Application No: CM/18/21/PL
Site Address: Land adj Mistletoe Farm Horsemere Green Lane Climping BN17 5QZ
Description of works: Erection of 1 No. 3 bed dwelling. This application is within CIL Zone 3 and is CIL liable as new dwelling.

Thank you for your internet representation made on 21st May 2021 which has been recorded as an objection with the comments as follows:

sheet 2 of 3

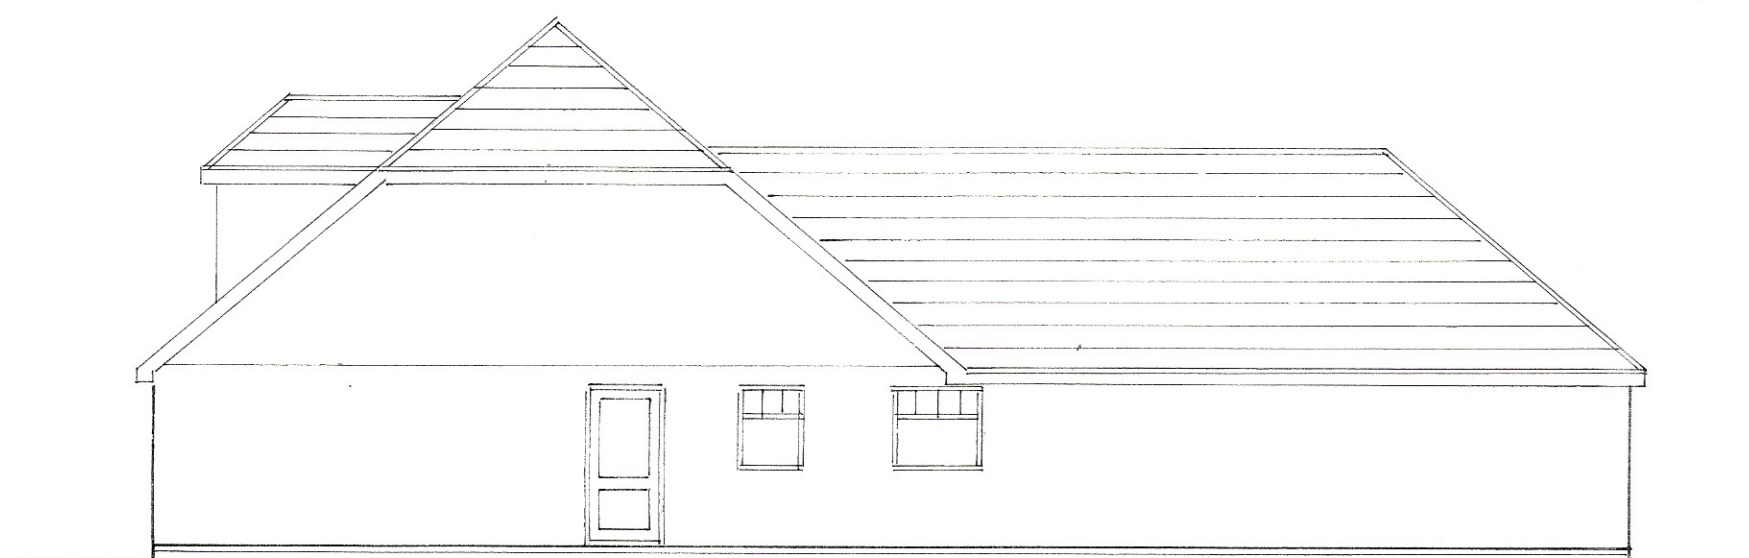
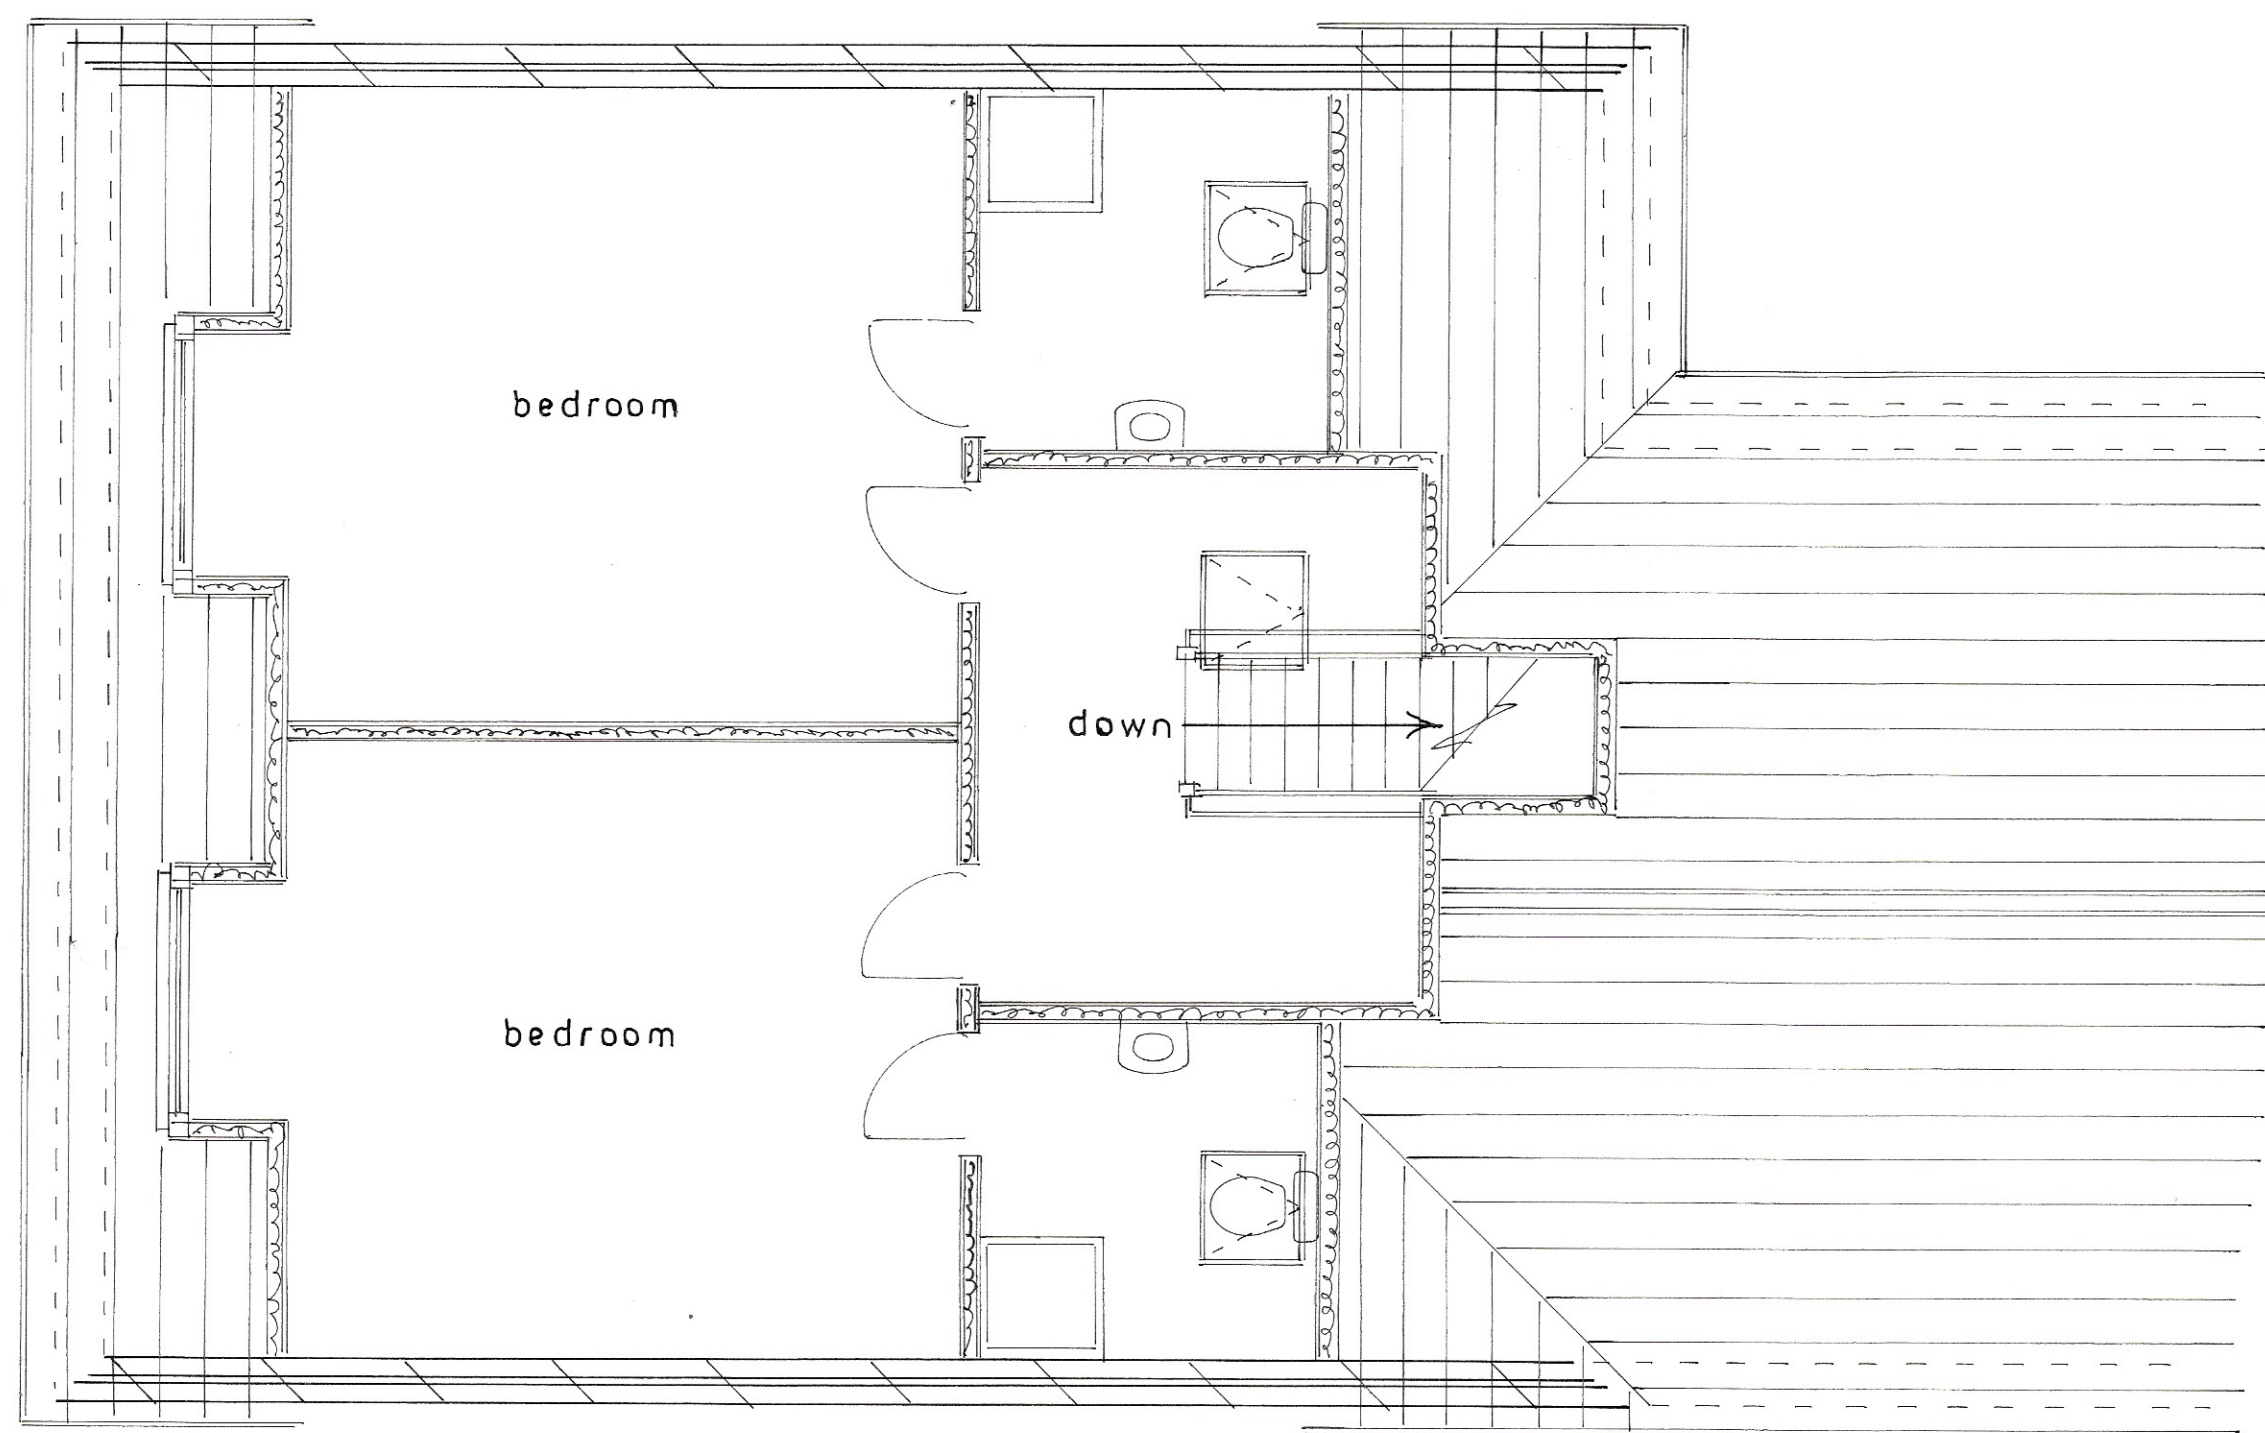
I pass Mistletoe Farm regularly and have noted the development already taking place very close to a family home. The proposals under this application
Would further negatively impact Mistletoe Farm has seem out of character with the neighbouring one-storey houses. One of the first floor windows would overlook the neighbouring house (Mistletoe Farm).
